DEPARTMENT OF PUBLIC WORKS

MEMORANDUM

SUBJECT: Big Creek Division I LPF-20-00001

TO: All Staff
FROM: Justin Turnbull, County Surveyor 
DATE: November 4, 2019
SUBJECT: County Survey Review of LPF-XX-XXXXX (Big Creek – Division 1)

BIG CREEK - DIVISION I
A PORTION OF THE N 1/2 OF THE SE 1/4 OF SECTION 29,
TOWNSHIP 20 NORTH, RANGE 14 EAST, W.M.
KITTITAS COUNTY, WASHINGTON

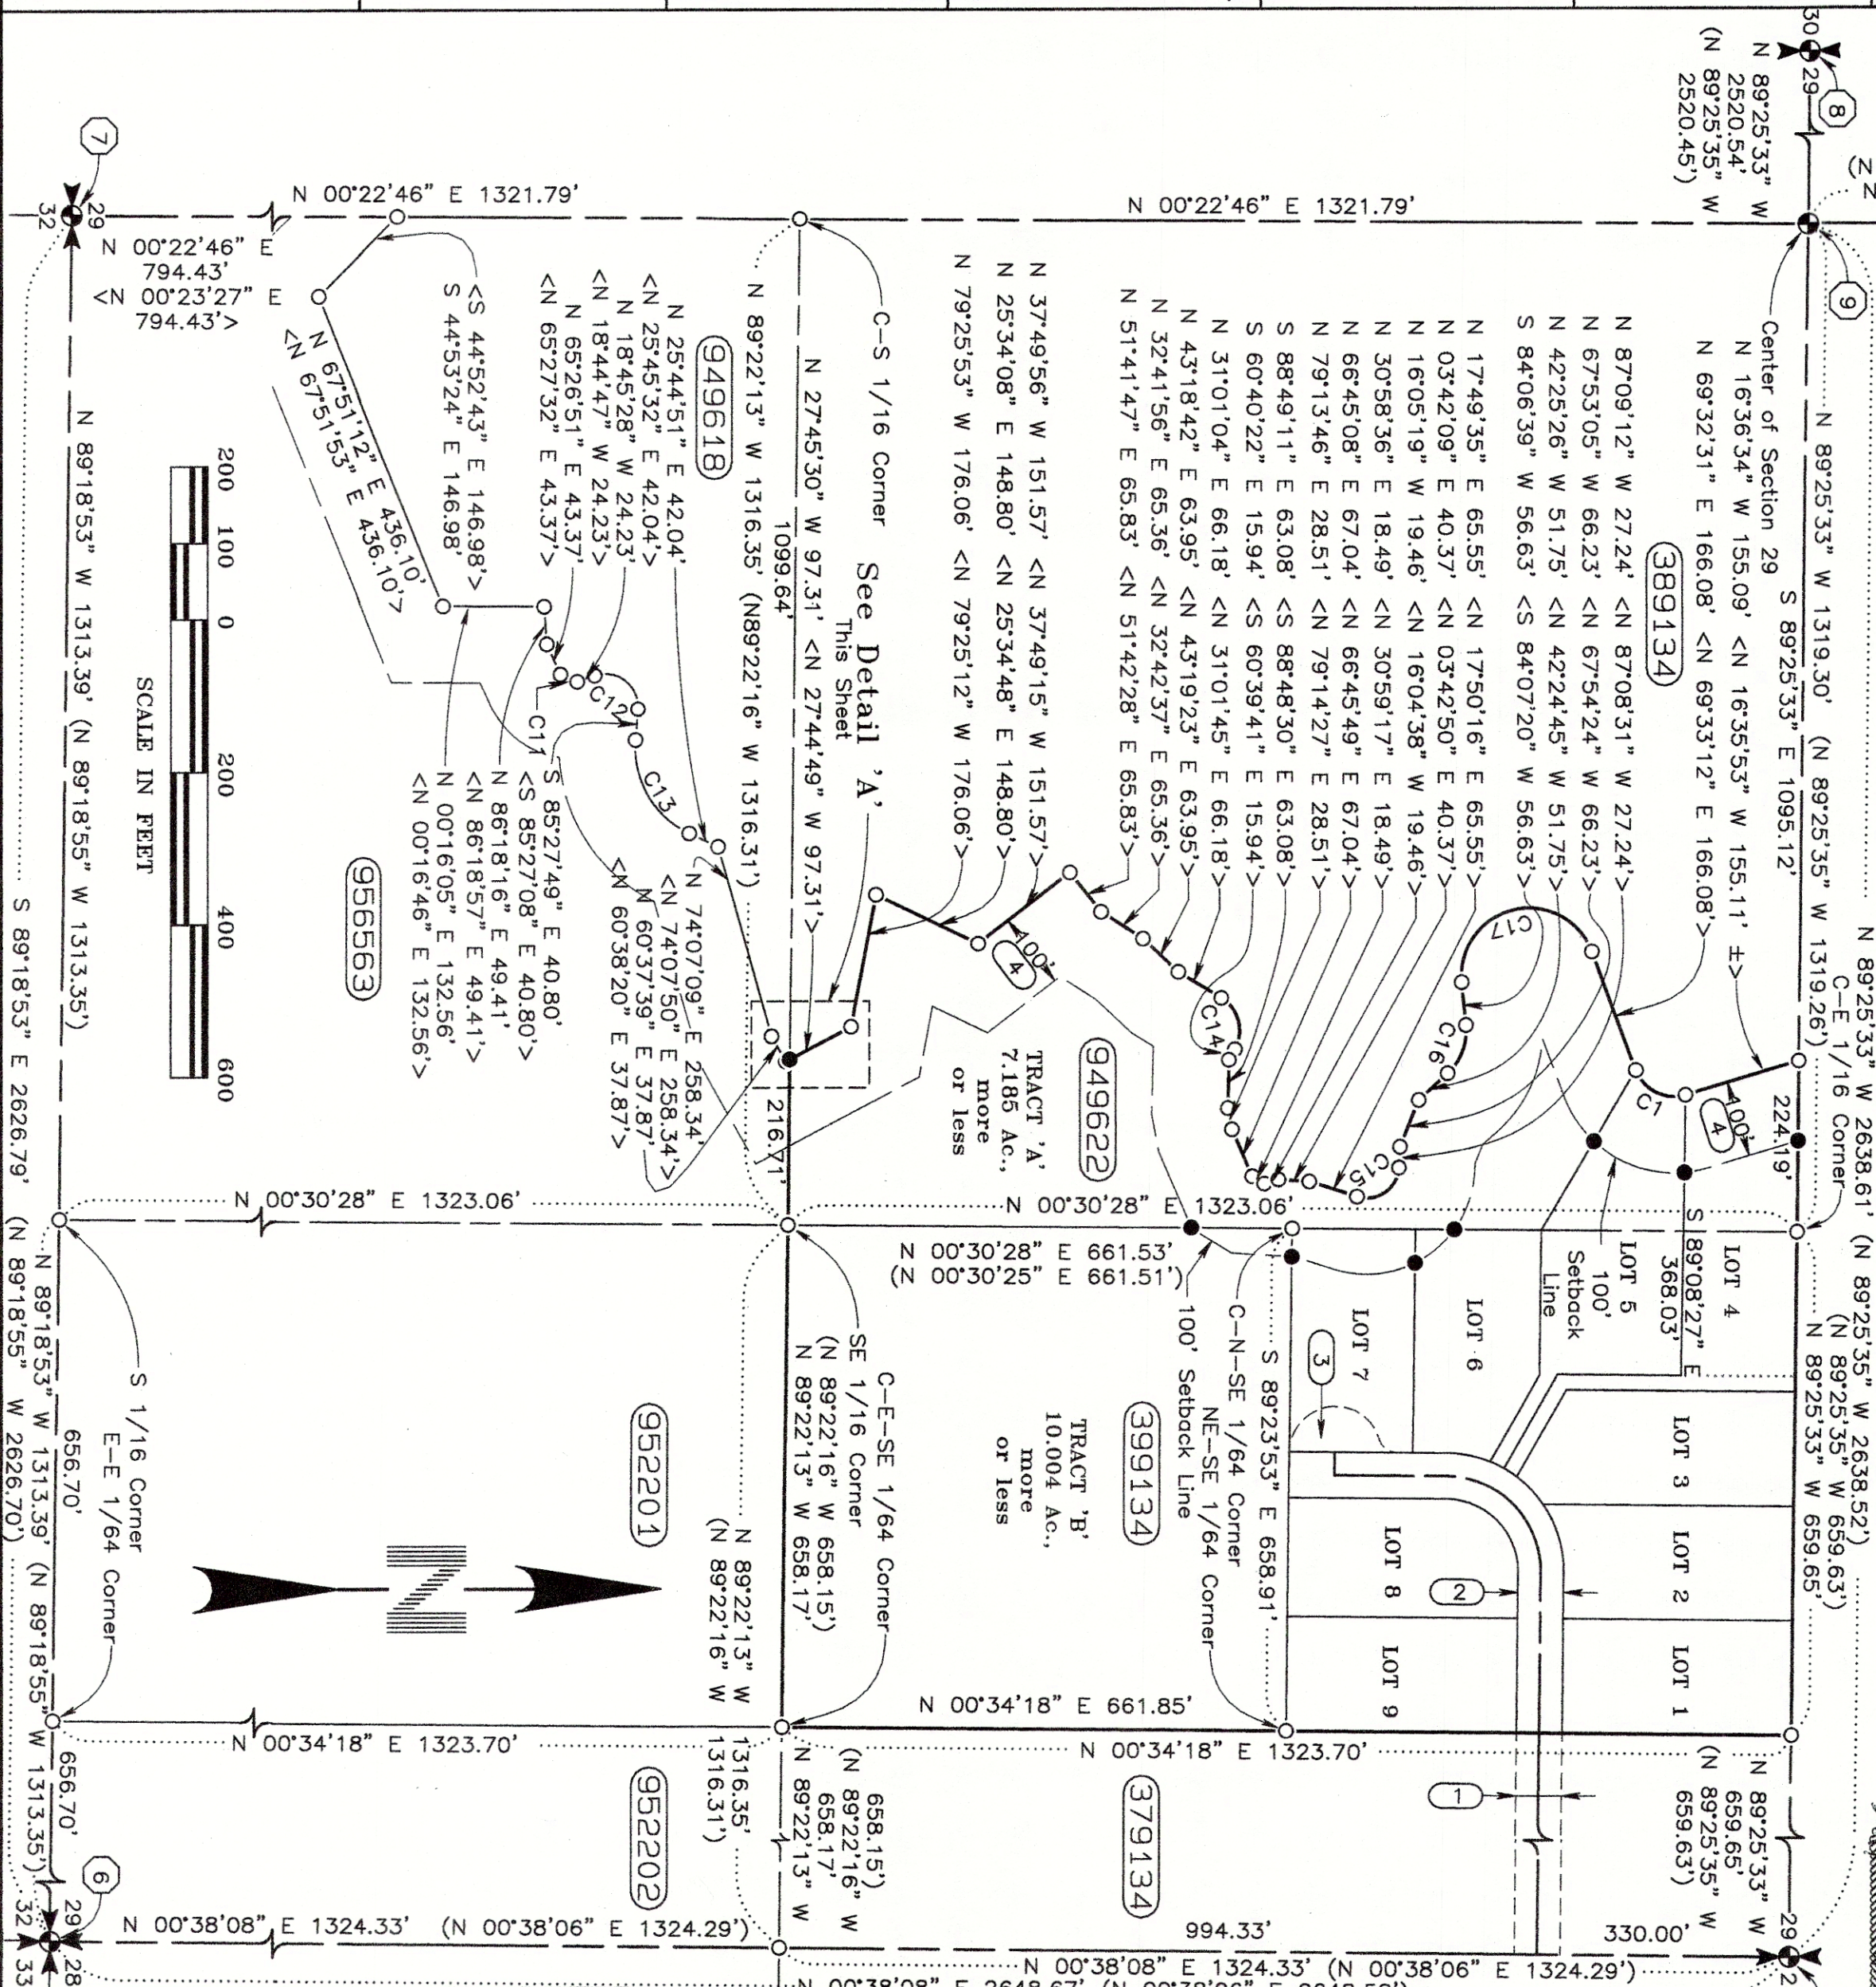
Lots 4 & 5: The current parcel configuration for lots 4 and 5 does not allow for adequate space to meet access spacing and driveway width requirements for separate driveways.

Public Road Access: The plat does not note the proof of legal access to connect to the public road system.

Easements: There are multiple existing access easements that may be impeded by this development. All access easements are required to be shown on the face of the plat. Easement "1" is inconsistent with the recorded easement it references.

1. The Plat as shown is suitable for a final plat, but does not meet the requirements for a preliminary plat per KCC:16.12, particularly in regards to contours, roads, ditches, water courses, and flood limits.

2. The Easement Denoted as '1' is inconsistent with the recorded easements it references. If this is just a manner of holding existing centerline of the existing roadway, rather than metes and bounds description it should be noted.

3. There are multiple access easements across the parcels that may be impeded by this development. How is this going to be addressed?
4. Big creek should be identified and labeled (see note 1)

5. The Basis of bearing refers to a B.O.R. bearing, but doesn't reference what this was taken from.
6. The East Line of Tract 'B' appears to have an incorrect distance. (132.53)

7. The dashed linework on the West boundaries of lots 6, 7 and Tract 'B' would make it difficult for the layperson to identify the lot limits.
8. The access to lots 4 and 5 do not meet county requirements.

9. The turnaround located at the end of the approach road is larger than required by code. There is no requirement to reduce the size.
10. The signatures on the face of the survey stamps are inconsistent with the name on the stamp.

11. The roadway should not be dedicated to the public, as the county has no interest in maintaining a public road section located at the end of a private access easement.

SHEET NO.
C1.4
143028
143029

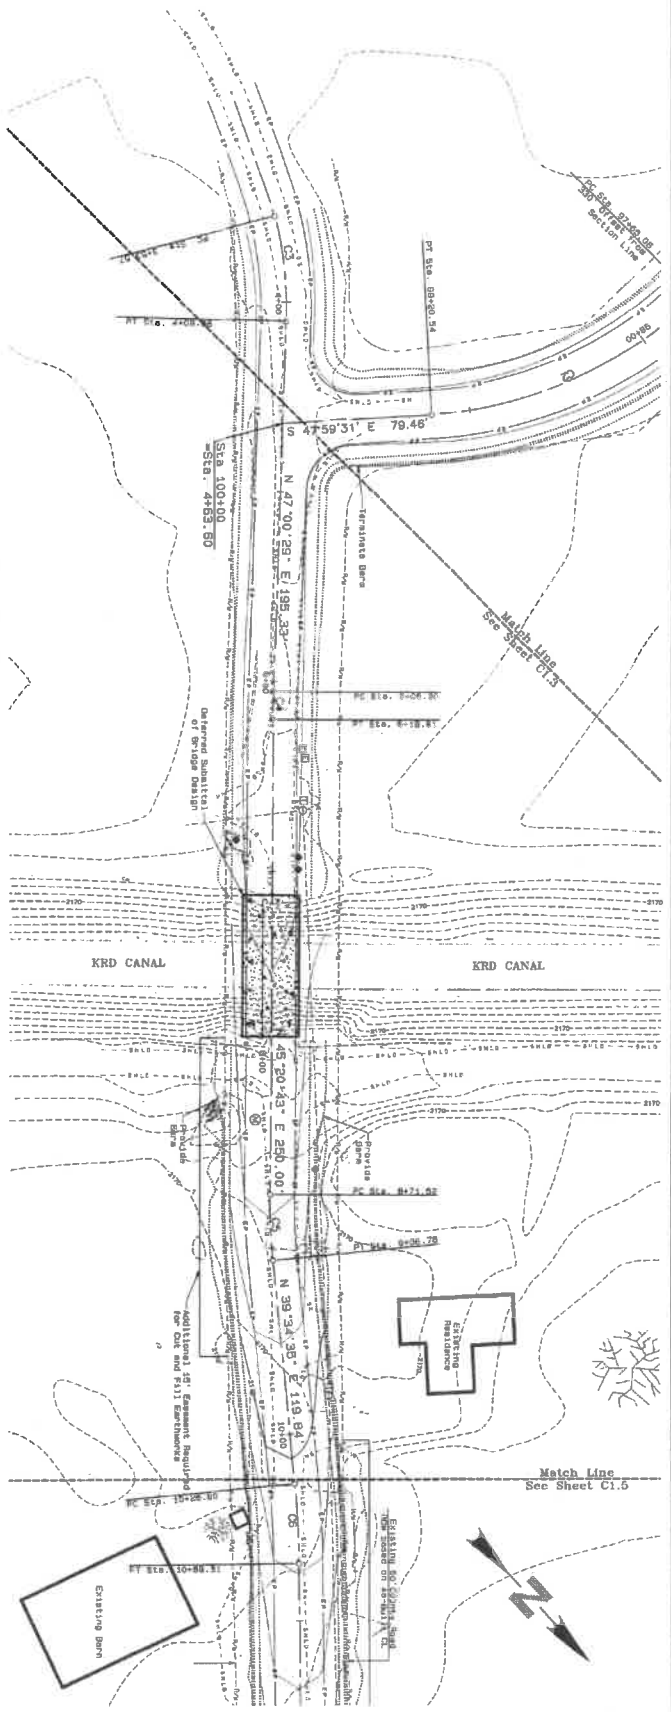
On the sheets C1.4 and C1.5, please consider amending the cut/fill slope easements to read "Additional Permanent Easement Required for Cut and Fill Earthworks."
